Your Ref: 2017/92268
Our Ref: T012371

8th September 2017

Cummins Turbo Technology, St Andrew's Road, Huddersfield - Erection of extensions, alterations to roofs and elevations and installation of sprinkler tank and pump house

Site Plan

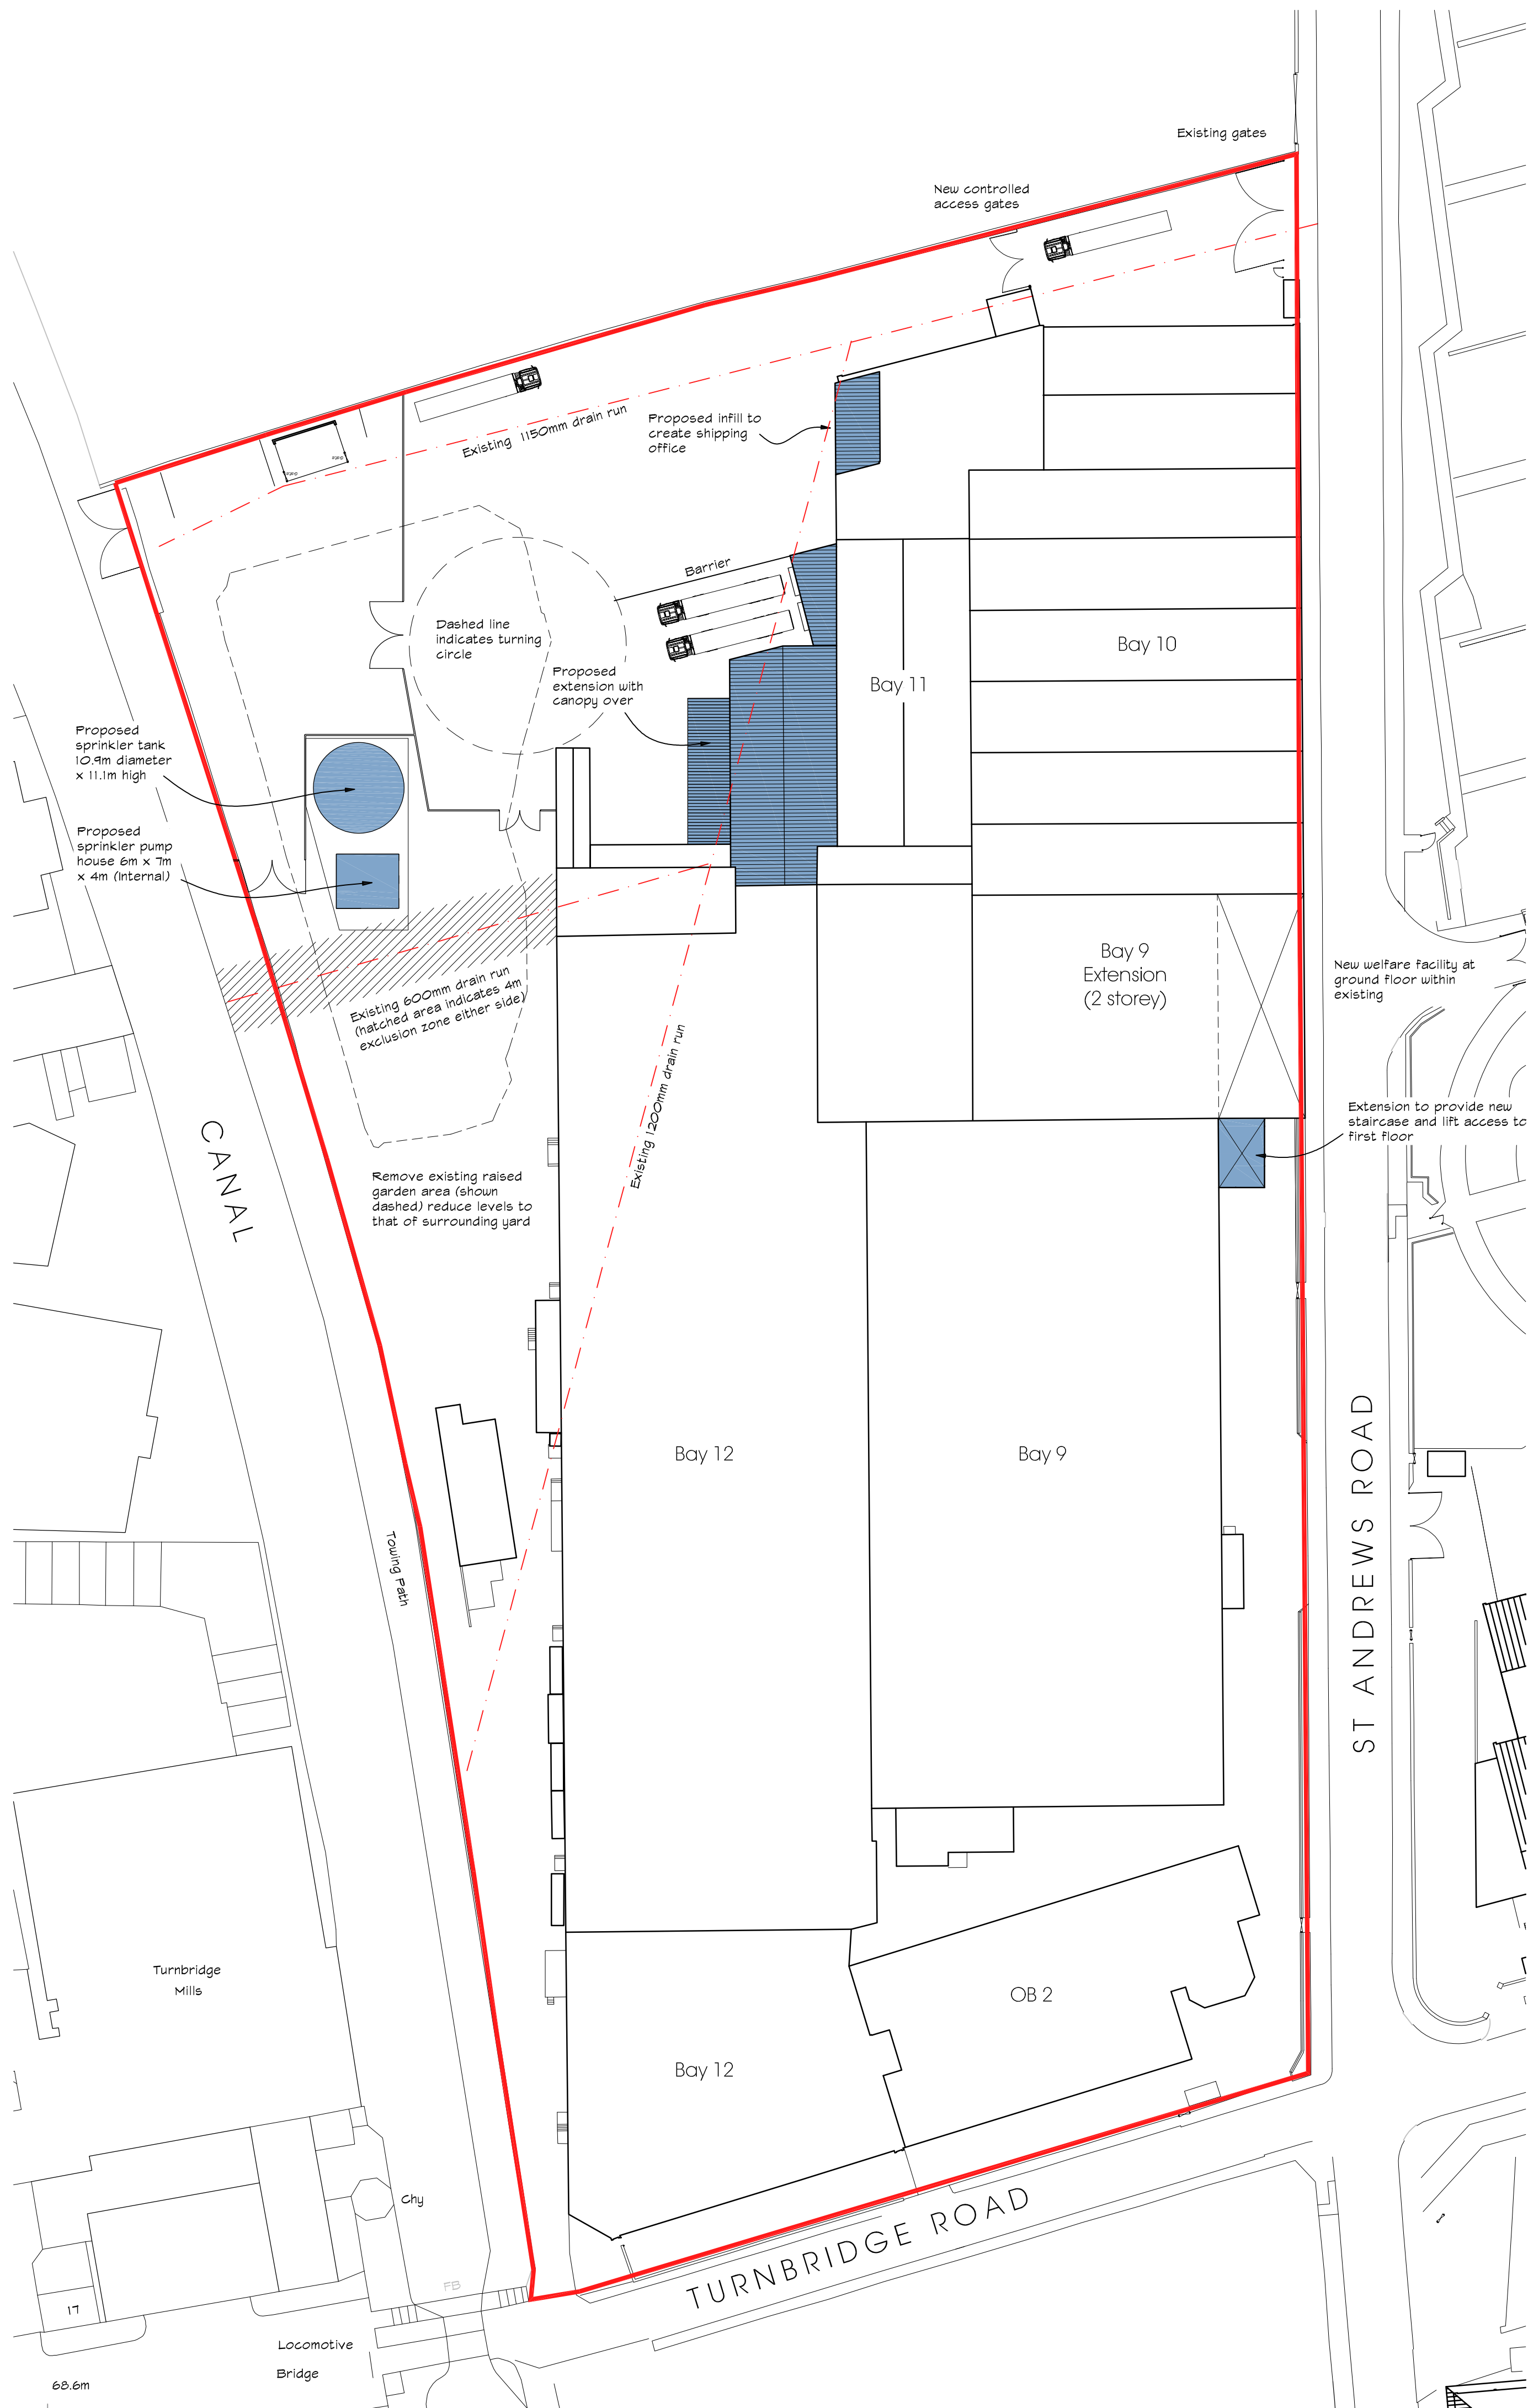
Thank you for re-consulting Yorkshire Water regarding the above proposed development. Following my letter of 14th August 2017 in which YW objected to the site layout because of the likely impact on the public sewerage, we have received a revised site layout.

1) On the Statutory Sewer Map, there are 1200 mm, 1150 mm, 600mm and 225 mm diameter public combined sewers recorded to cross the site. A stand-off distance of 4 (four) metres is required at each side of the 600 mm sewer centre-line and a formal build- over agreement will be required for a section of the 1200 mm sewer to be built over. Submitted drawing 16-C34-08 (revision B) dated 22/08/2017 prepared by Farrar Bamforth Associates Ltd appears to reflect these requirements but I would like the above condition to be attached if planning permission is granted to protect the 600mm pipe against future impact perhaps via permitted development rights and to ensure the 1200mm pipe is not damaged because of construction works. The other sewerage laid in the site will not be affected by the development.

3) The developer is proposing to discharge surface water to public sewer however, sustainable development requires appropriate surface water disposal and Yorkshire Water promotes the surface water disposal hierarchy. The developer must provide evidence to demonstrate that surface water disposal via infiltration or watercourse are not reasonably practical before considering disposal to public sewer. Only as a last resort should curtilage surface water discharge to the public sewers recorded to cross the site at a maximum rate of 5 five litres per second.

No building or other obstruction including landscape features shall be located over or within 6 metres either side of the centre line of the public sewer i.e. a protected strip width of 12 metres, that crosses the site. If the required stand-off distance is to be achieved via diversion or closure of the sewer, the developer shall submit evidence to the Local Planning Authority that the diversion or closure has been agreed with the relevant statutory undertaker and that prior to construction in the affected area, the approved works have been undertaken. Furthermore, construction in the relevant area of the site shall not commence until evidence has been submitted to and approved by the Local Planning Authority that a formal build-over agreement with respect to the 1200mm diameter sewer that is laid within the site, has been reached with the statutory sewerage undertaker.
(In order to allow sufficient access for maintenance and repair work at all times)

No development shall take place until details of the proposed means of disposal of surface water drainage, including details of any balancing works and off-site works, have been submitted to and approved by the Local Planning Authority. Any discharge to public sewer shall be subject to evidence being submitted to and approved by the Local Planning Authority that demonstrates that surface water drainage from the whole site to watercourse is not reasonably practical and shall then be subject to a maximum rate of discharge of 5 (five) litres per second. Furthermore, unless otherwise approved in writing by the Local Planning Authority, there shall be no piped discharge of surface water from the development prior to the completion of the approved surface water drainage works.
